City of Albuquerque

September 4, 2001

**RE: Grading and Drainage Plan for Edith Blvd. and Granite Ave. NE (J-14/ D141),
Engineer's stamp dated Sept. 1, 2001. (J-14,15)**

DRAINAGE AND GRADING PLAN FOR GRANITE STREET & EDITH BLVD

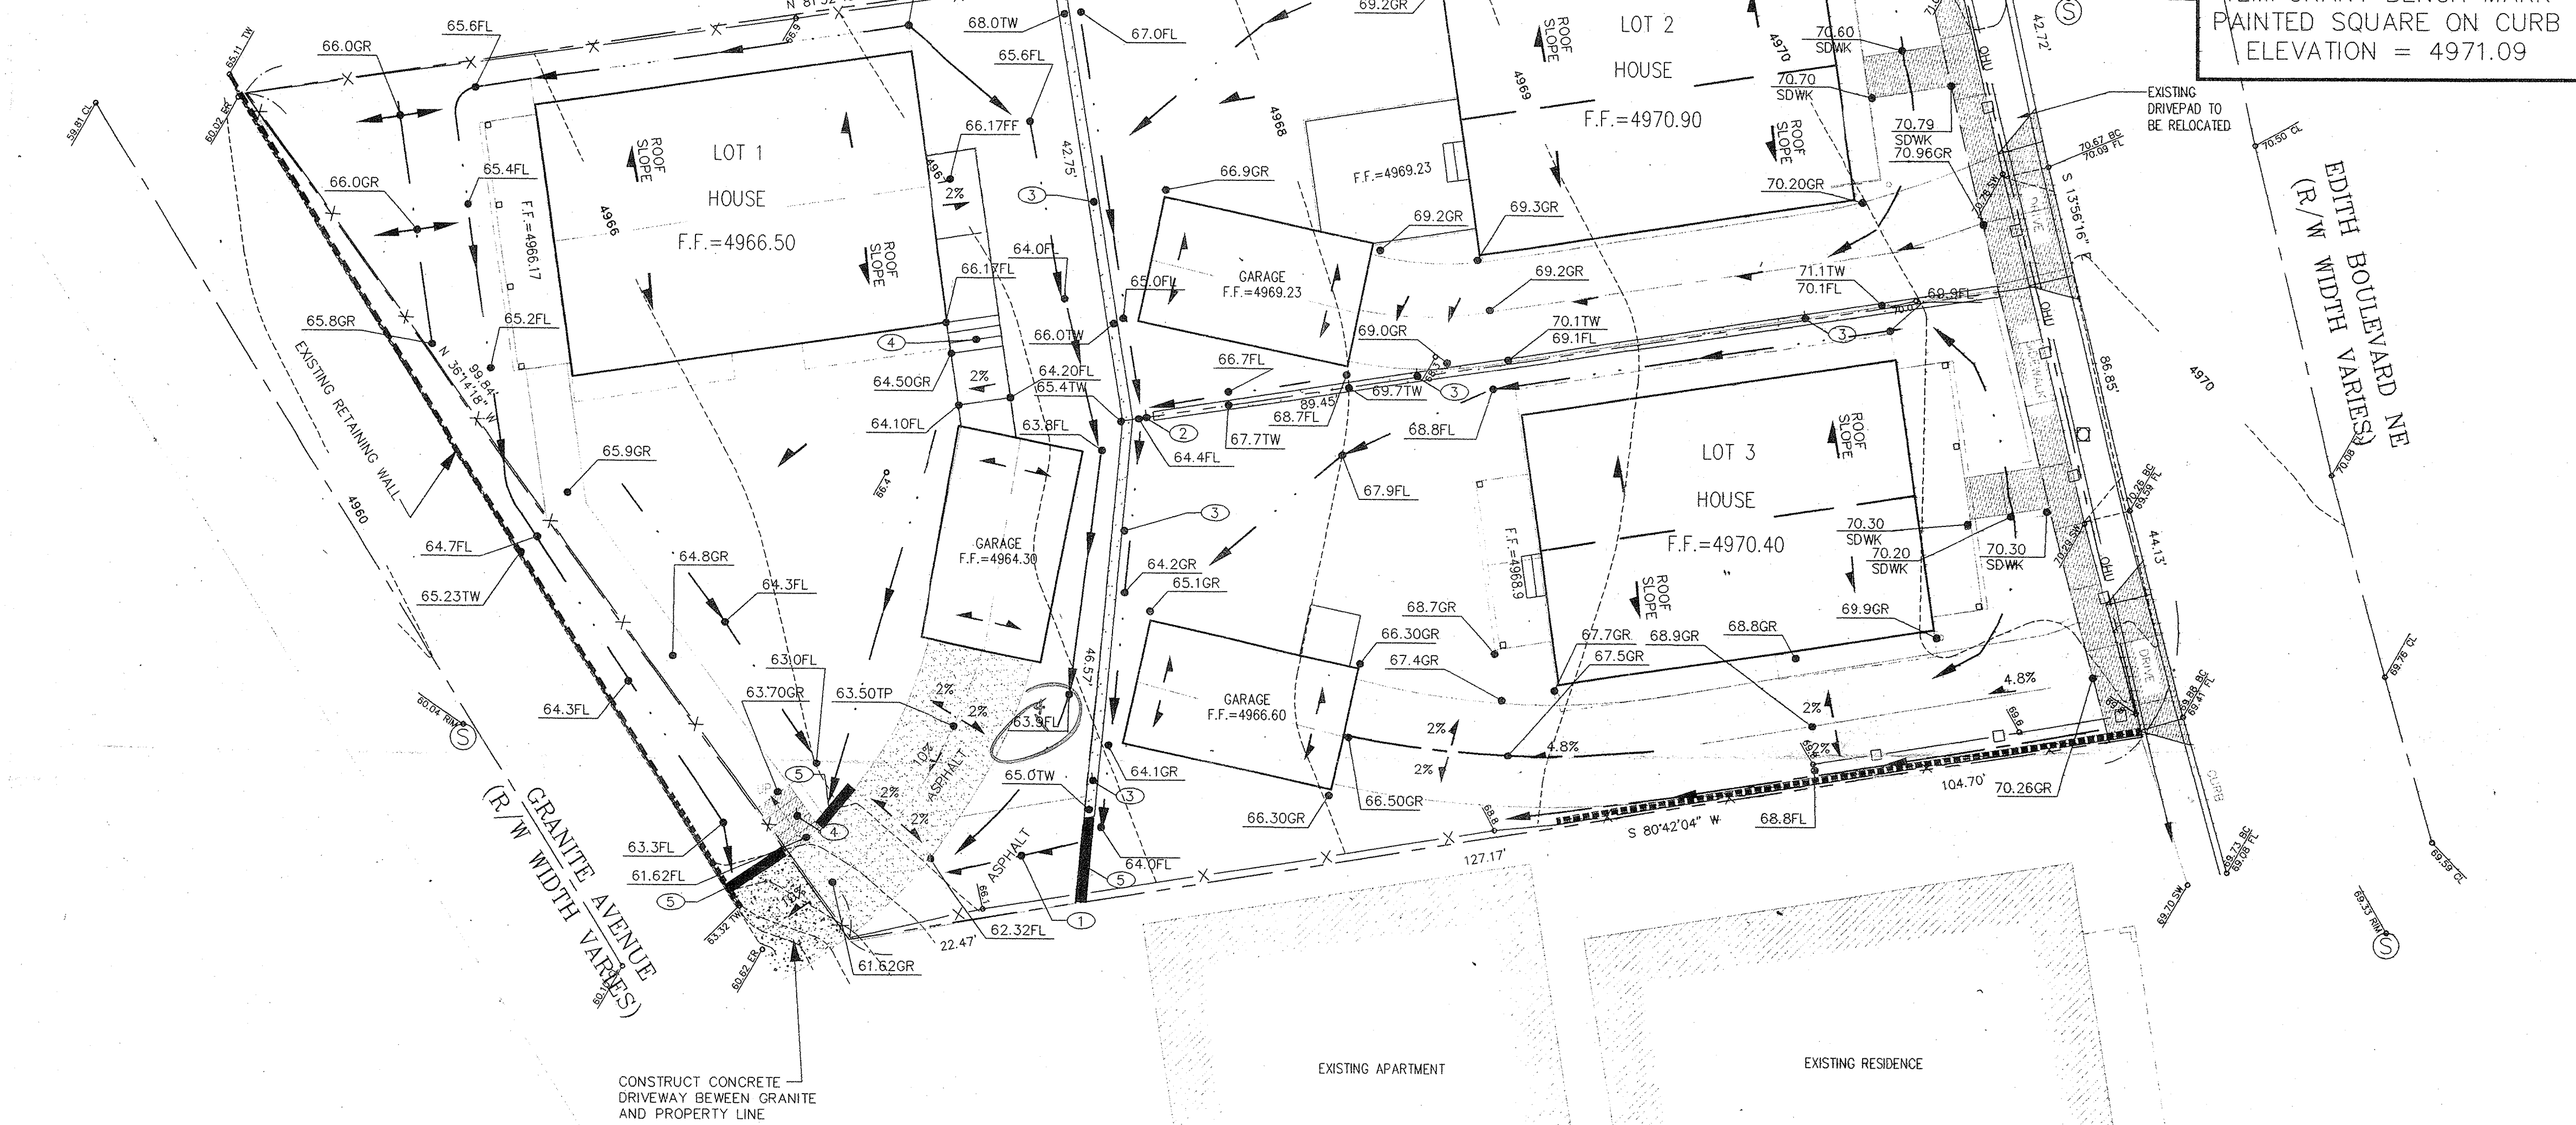
- **Lower the ground elevation at the southeast corner of the garage on Lot 1. The elevation 63.9FL won't work. Make it 63.4FL. This will ensure positive drainage around the east side of the garage.**
